From:
Sent: 26 April 2019 18:23
To: DCAdmin
Subject: Objection to planning Application Number 2019/91141
Attachments:

We would like to raise an objection in relation to the proposed single dwelling on land adjacent to 320, New Hey Road, Oakes, Huddersfield, HD3 4GQ; 2019/60/91141/W.

STREET ELEVATION FROM
NEW HEY ROAD

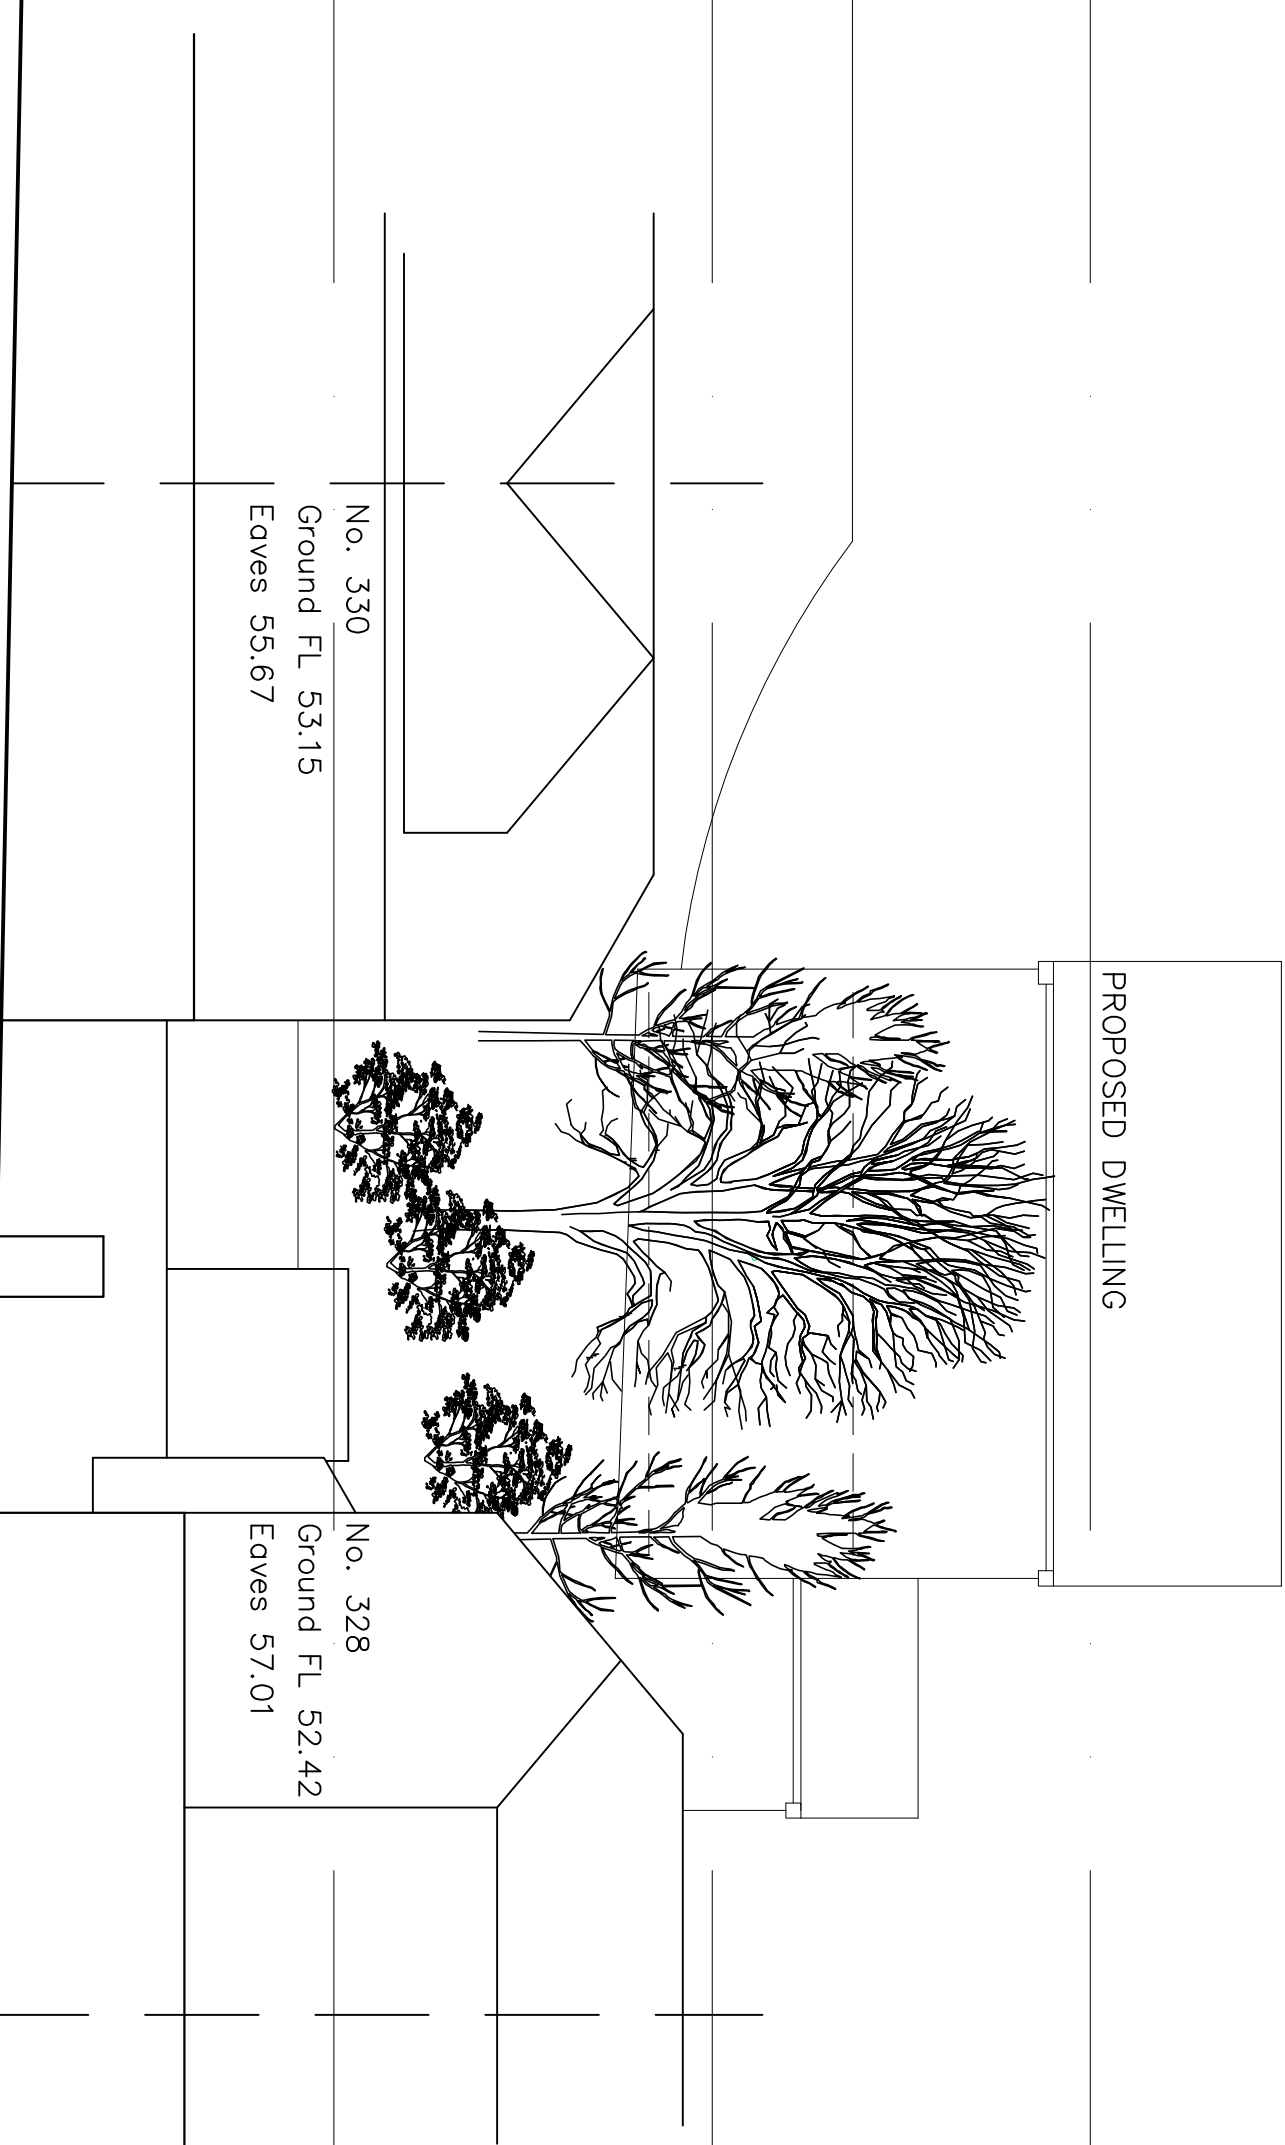
We note the dimensions on the proposed scale drawing and have cross referenced this with the previous application street scene drawing. While we note there are no windows presented at this time, one would assume there will be habitable rooms to the first floor. If any of these were to have a window facing South or East a total and utter loss of any and all privacy to the adjacent properties would occur, even considering the surviving trees and potential boundary fences where present. Due to the proximity and steep topographical position the dwelling would present as an overbearing dwelling with significant impact

SITE PLAN

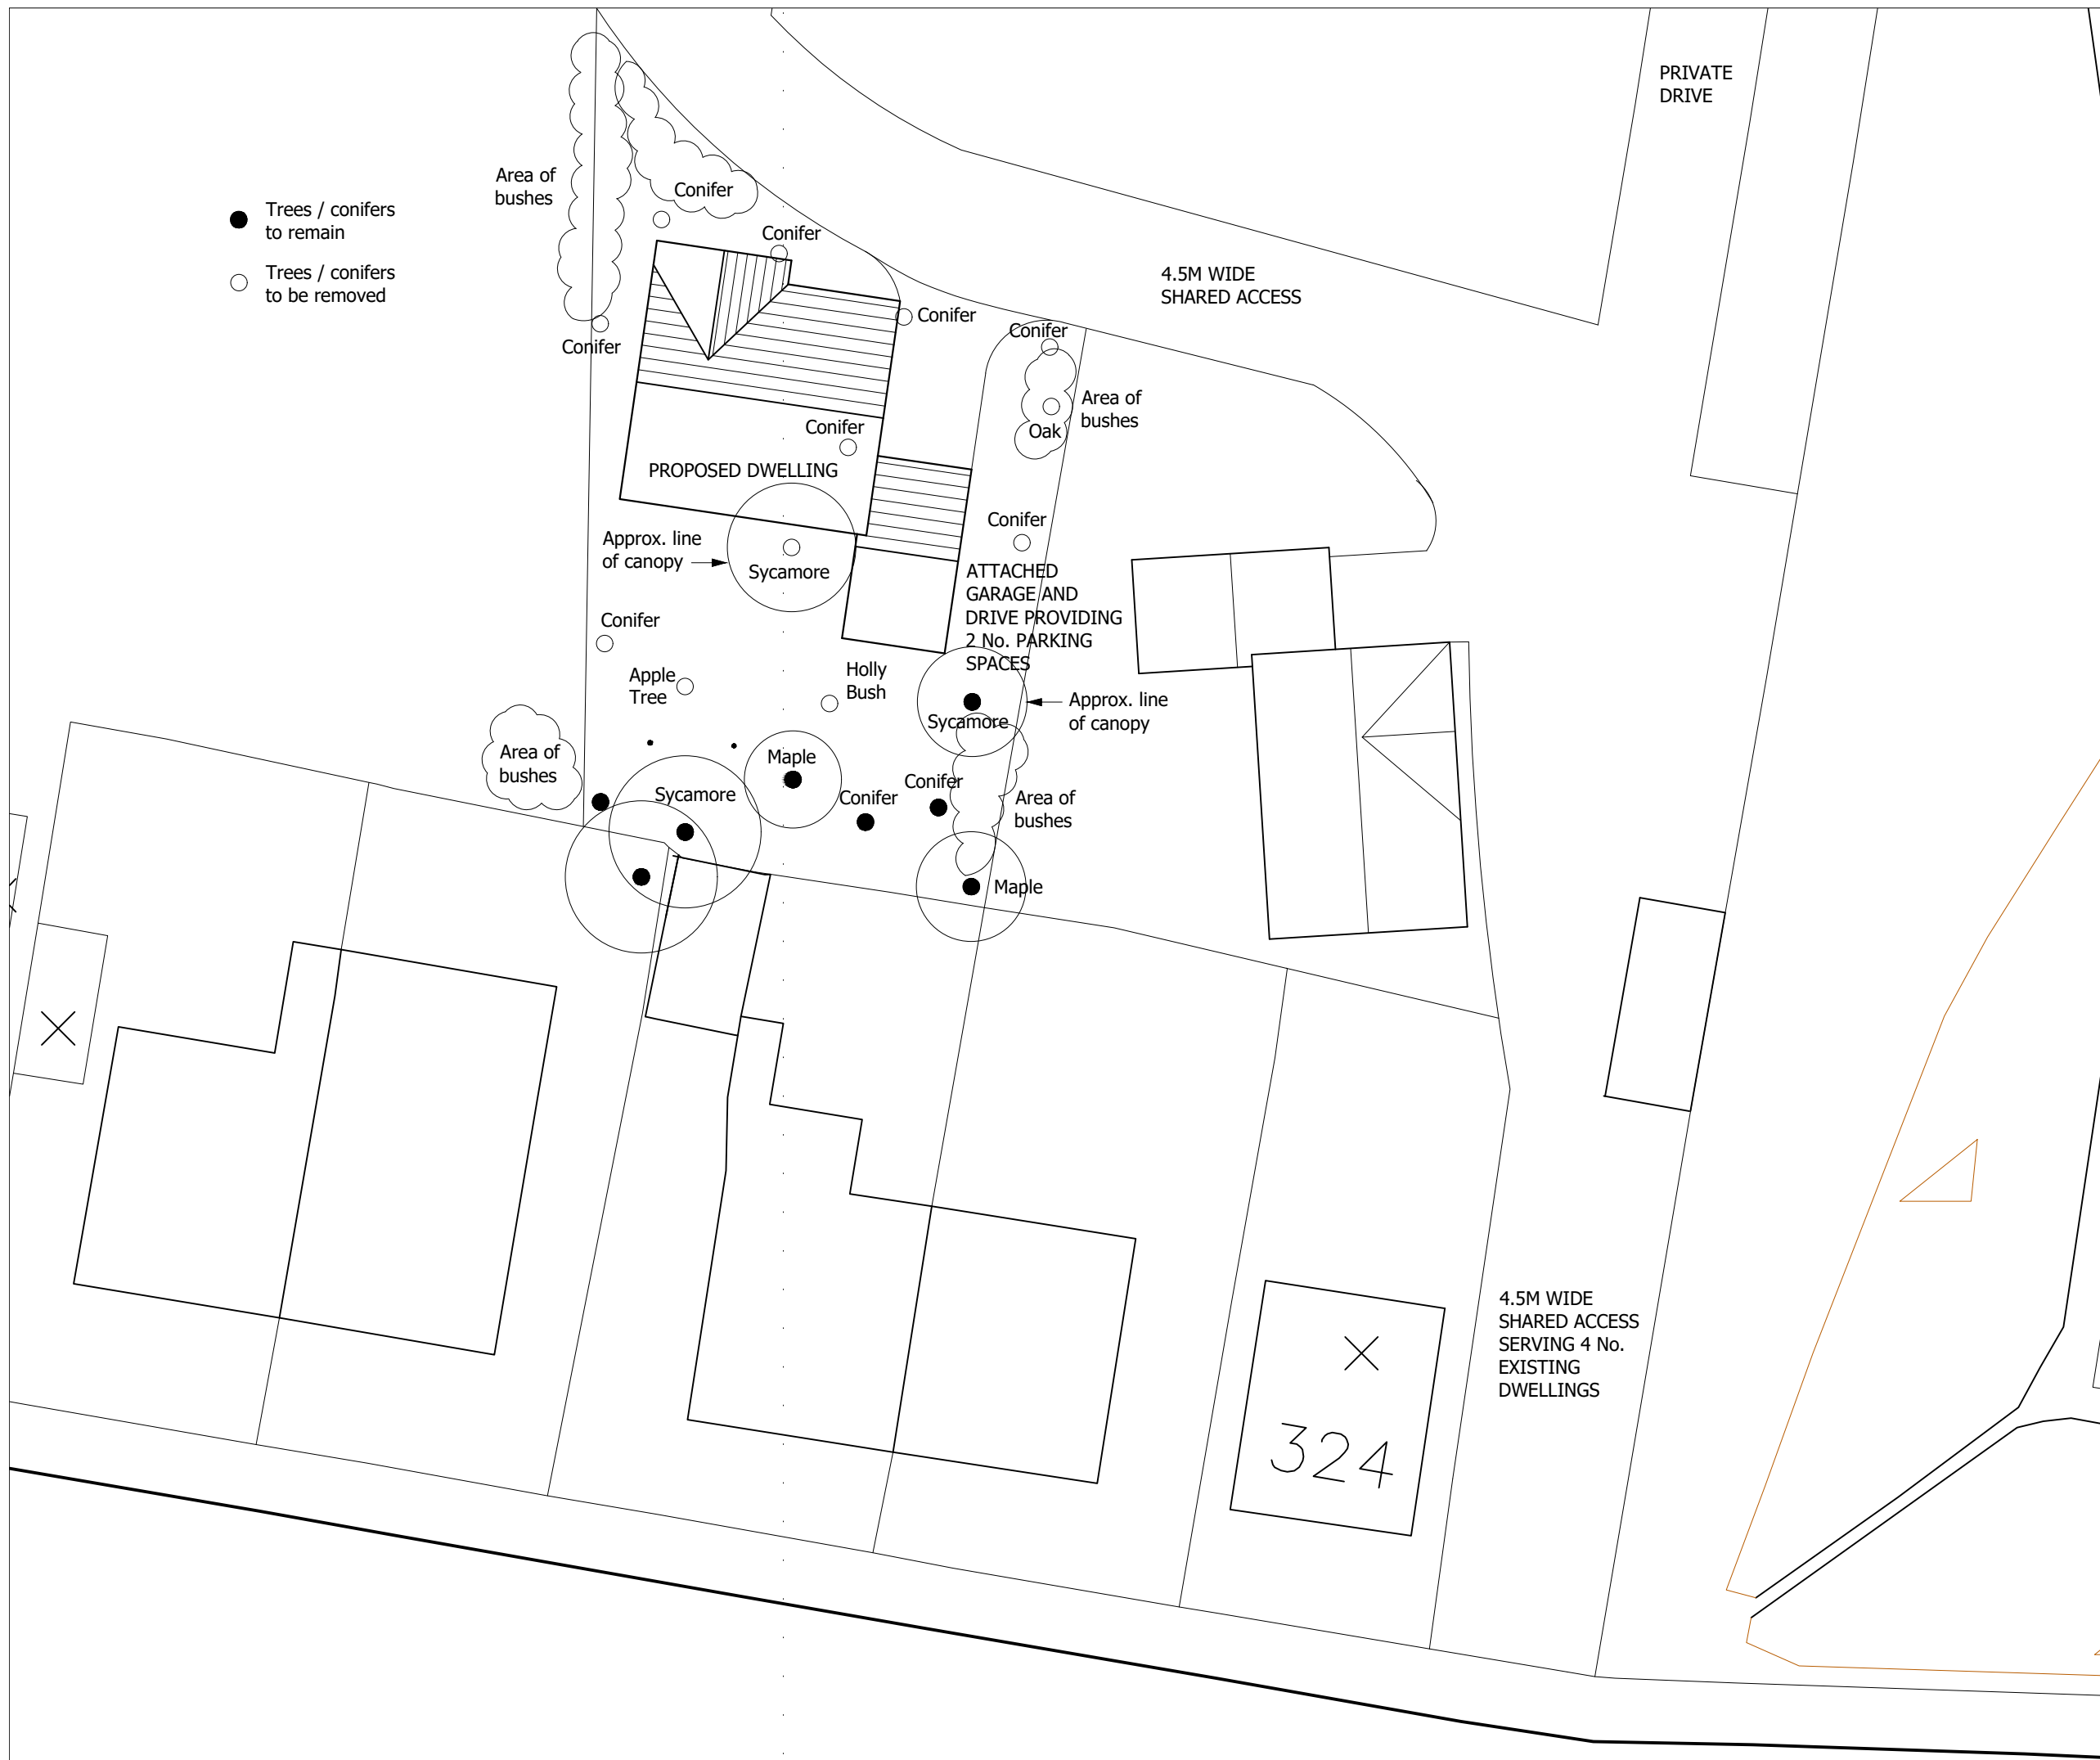
The proposed site block plan is inadequately drawn with no North arrow and demonstrates some obvious anomalies which would have bearing on any proposed dwelling;

The House to the assumed East of the proposed dwelling is orientated at an angle and is not parallel to the bungalows to New Hey Road as shown reducing the actual amenity space this property enjoys, this reduced size space will now assumingly be overlooked and lose significant private space.

The proposed block plan shows the trees in locations that do not correspond with the locations on site, giving a false representation of where the house might finally be sited.

House number 330 has an extension to the rear which accommodates a dining and kitchen area (habitable room) which is closer to the proposed dwelling than is currently indicated.

We have measured this, and it would be no further away than 15.617 Metres if the block plan is drawn accurately. Please see attached drawing.
